Recommendation Report for Planning Permission for Works or Extension to a Dwelling

REF NO: AW/288/18/HH

LOCATION: 8 Osborne Way
Bognor Regis
West Sussex
PO21 3DN

PROPOSAL: Single storey front extension

PROPOSED GROUND FLOOR PLAN

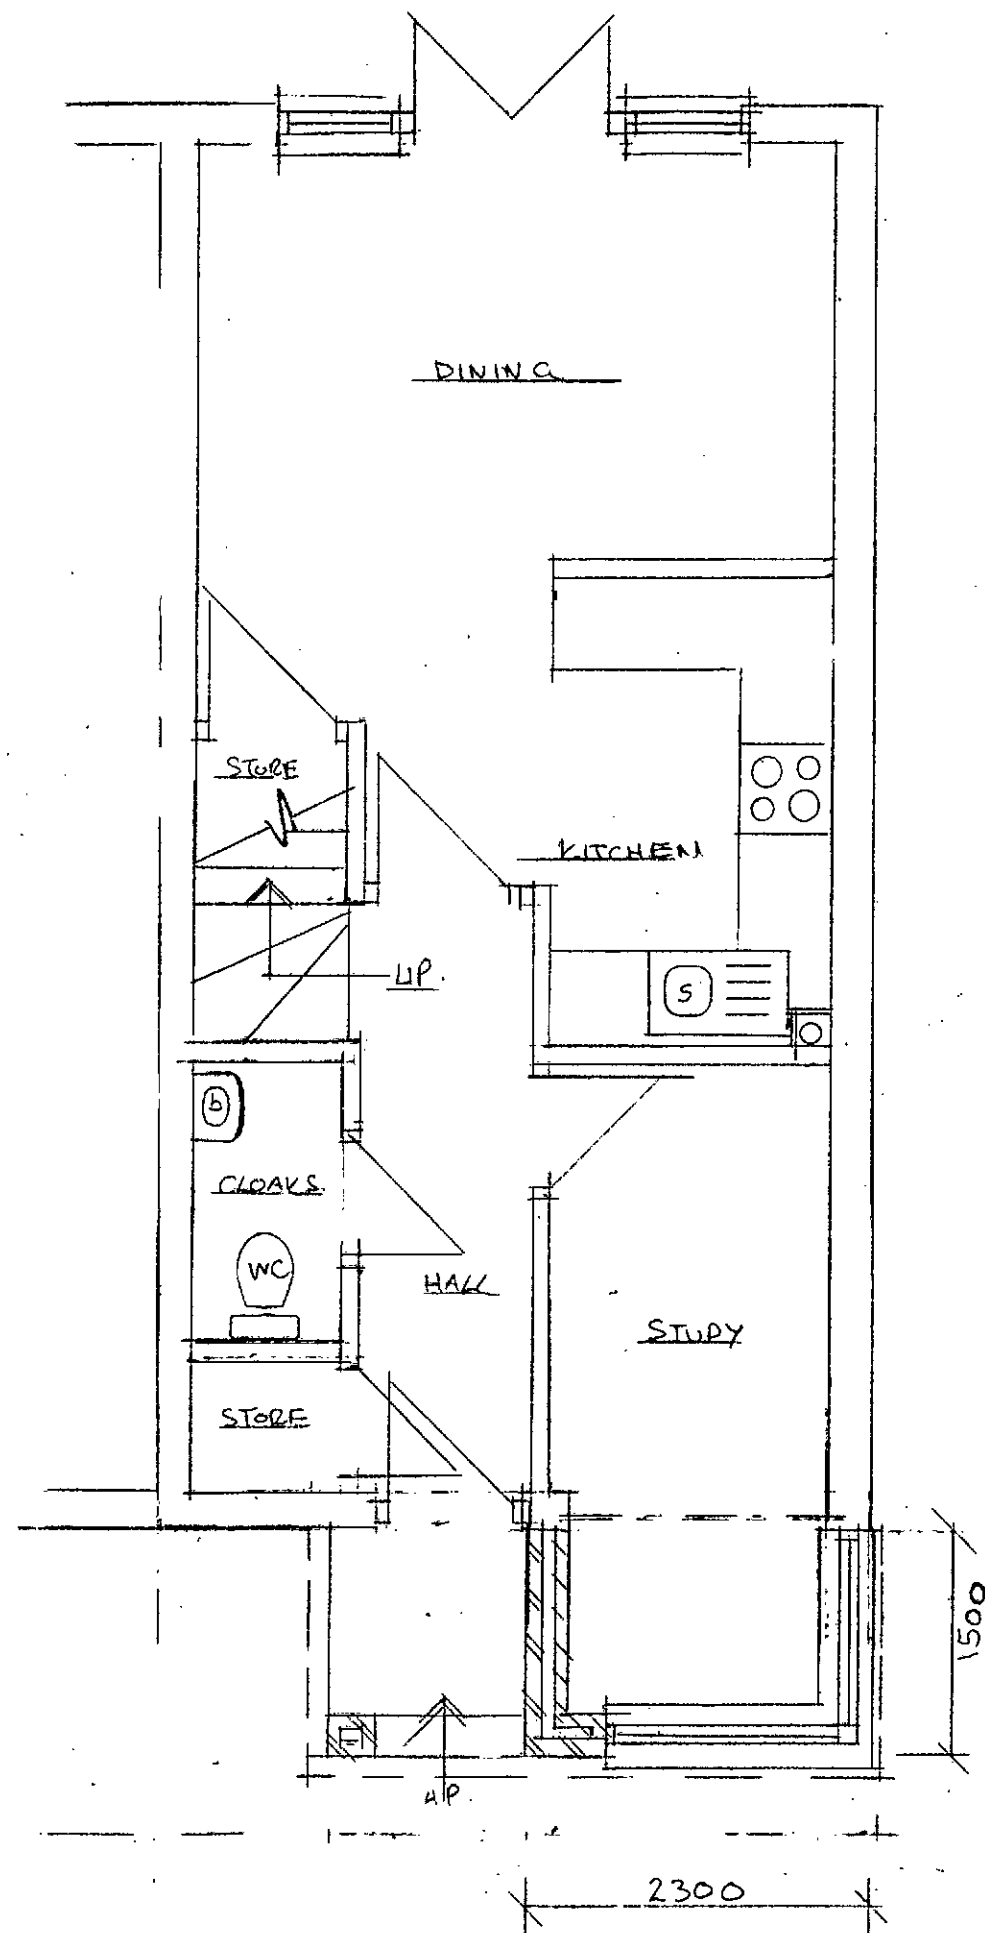
Proposal not in keeping with existing dwelling - Does not sympathetically relate to and is not visually integrated with existing building in siting, massing, design and materials.

Would have adverse overlooking, overshadowing or overbearing effect on neighbouring properties.

Objection has been raised by Aldwick Parish Council where they consider that the proposal is not in keeping with existing dwelling. They state that it does not sympathetically relate to and is not visually integrated with existing building in siting, massing, design and materials.

Objection has been raised by Aldwick Parish Council where they consider that the proposal would have adverse overlooking, overshadowing or overbearing effect on neighbouring properties.

The front extension would be set in from the boundary of adjoining property no.6 by approximately 1 metre to the bottom of the proposed pillar (brick portion). The part of the extension closest to the common boundary of no. 6, would be open sided with the nearest wall of the proposal set in from the common boundary by approximately 2.42m. It is considered that the proposal would not have an overshadowing or overbearing effect upon the occupiers of adjoining and neighbouring properties.

plans and Officer's visit, the proposal would be acceptable in design terms as it would be of a size and scale that harmonises with the original dwelling. The proposal would not be unduly prominent or out of keeping with the design and external appearance of the application dwelling.

It is considered that the proposed extension would sympathetically relate to and would be visually integrated with, the existing building in siting, massing, design, form scale and materials and would comply with Policy D DM1 and criteria a, b, d and e of Policy D DM4 of the Arun Local Plan 2011-2031.

Any overlooking would be out toward the highway and over areas to the front of dwellings that are used for parking, areas that are already overlooked. Therefore no detrimental overlooking would occur.
